## Engineers Comments Regarding Surface Water Drainage

| <b>Application Reference:</b>   | <b>WA/11/26/HH</b>                                                                                              | <b>Reviewer Reference:</b> | ADC/JD/KW/PC |
| <b>//Site Name://</b>           | Rose Cottage Dairy Lane Walberton BN18 0PT                                                                      |                            |              |
| <b>Application Description:</b> | Construction of a detached, single storey, timber framed granny annexe for ancillary use to the main dwelling.. |                            |              |

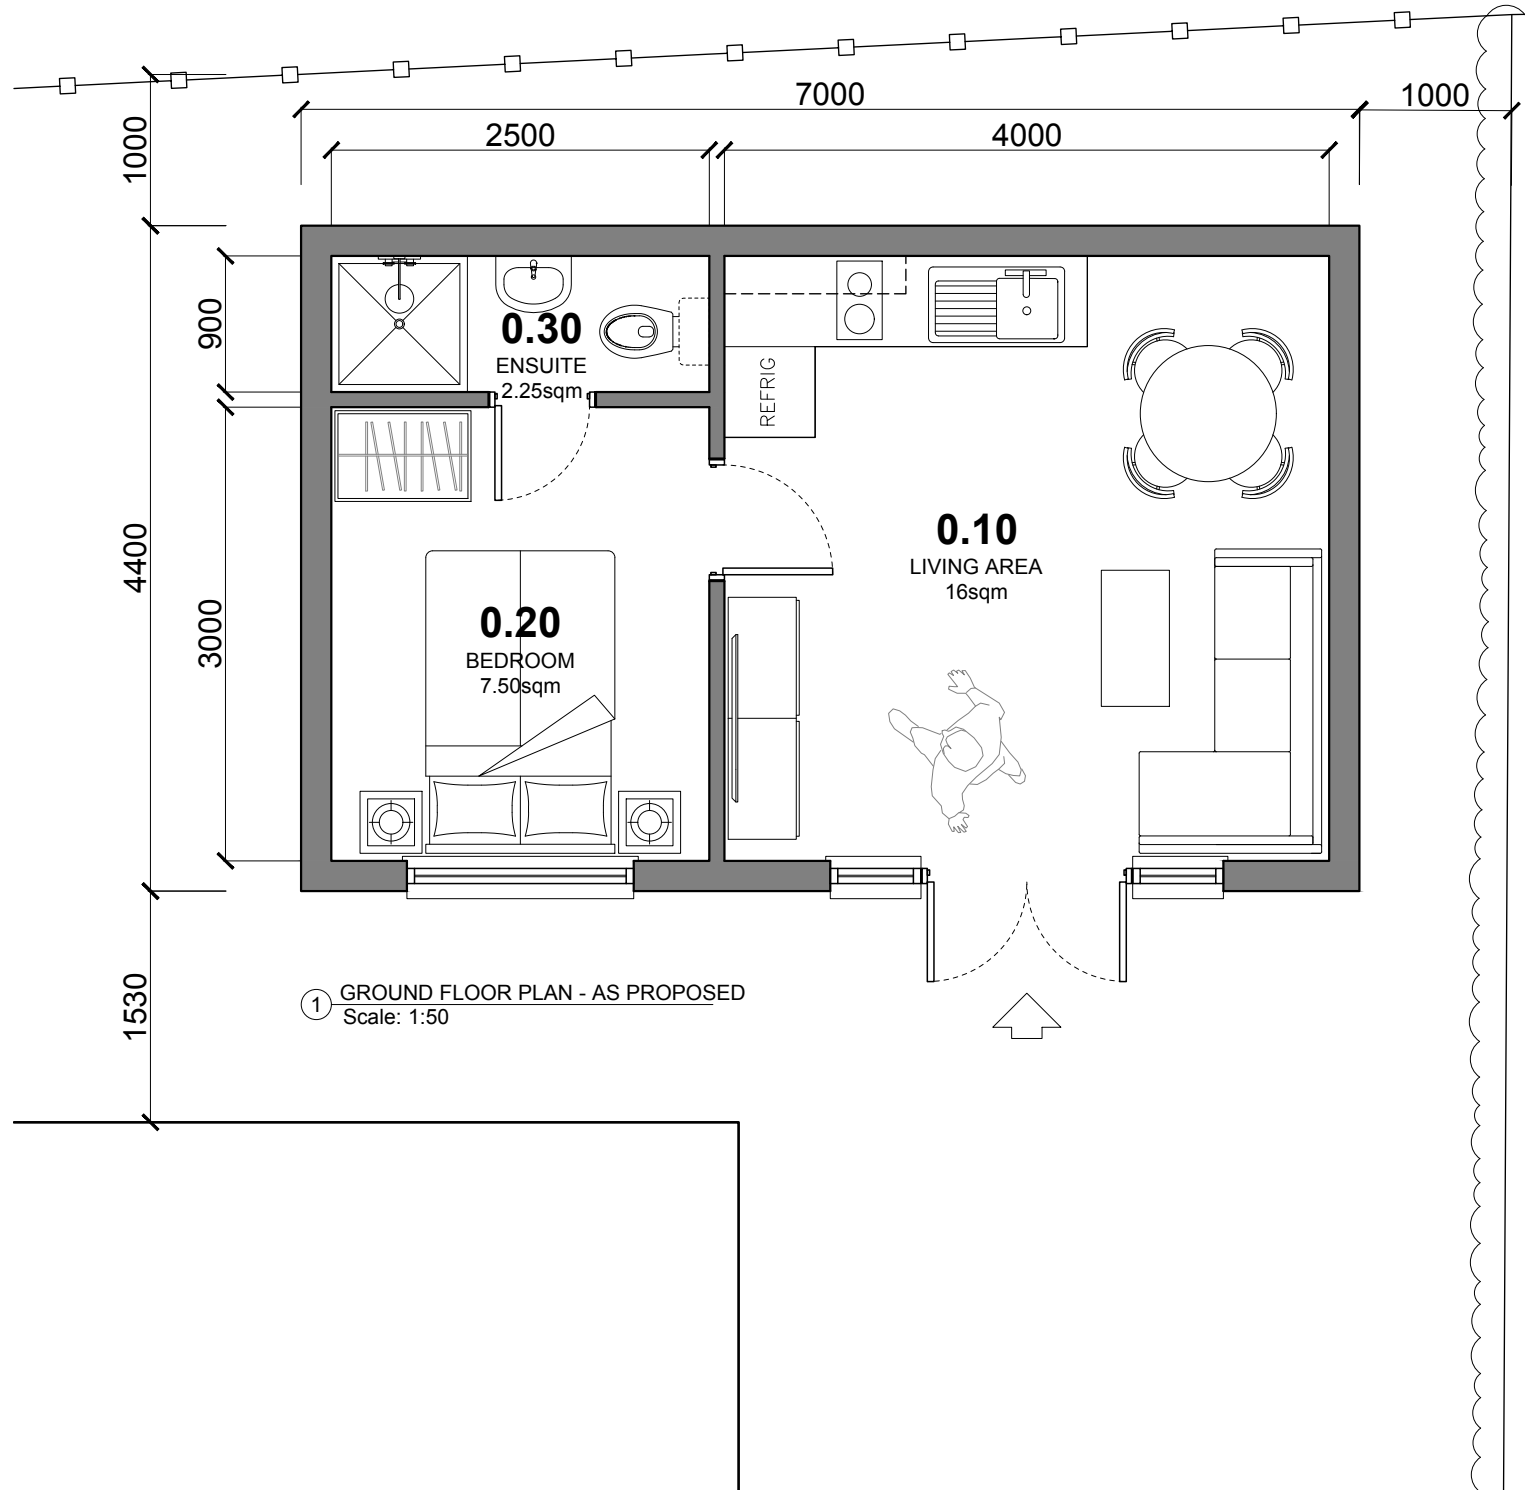
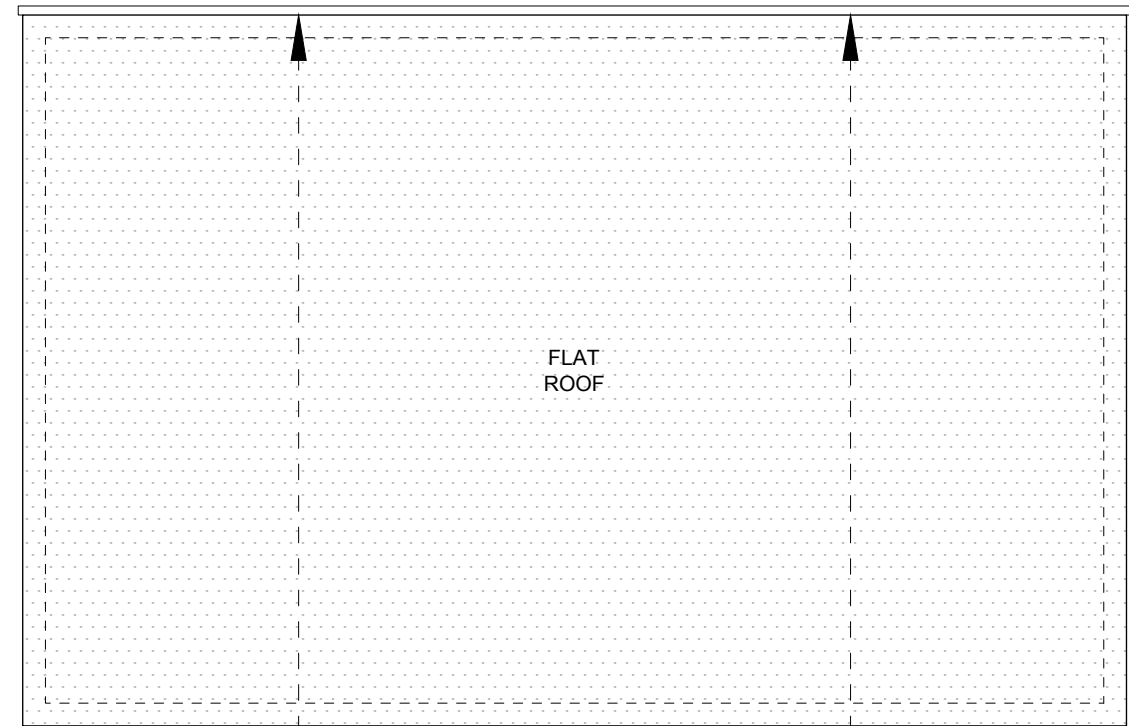
- 1.4. Even where infiltration is viable, space to locate SuDS features are constrained on this site due to the extremely shallow rear garden space. This is important as the proposed development limits where an infiltration feature can be located. Soakaways must be at least 5m from buildings and highways. The block plan indicates that the building will be approximately 1.1m from the boundary at the east, 1.6m from the boundary on the west, 2.25m from the boundary at the north, and 1m from the boundary at the south. This would not leave sufficient space for a soakaway. Indeed, the proposed extensions may disrupt existing soakaways, which have not been assessed for the purposes of this submission. If the existing drainage of the property or neighbouring properties is disrupted and there is no space for an alternative, then flood risk will be increased.
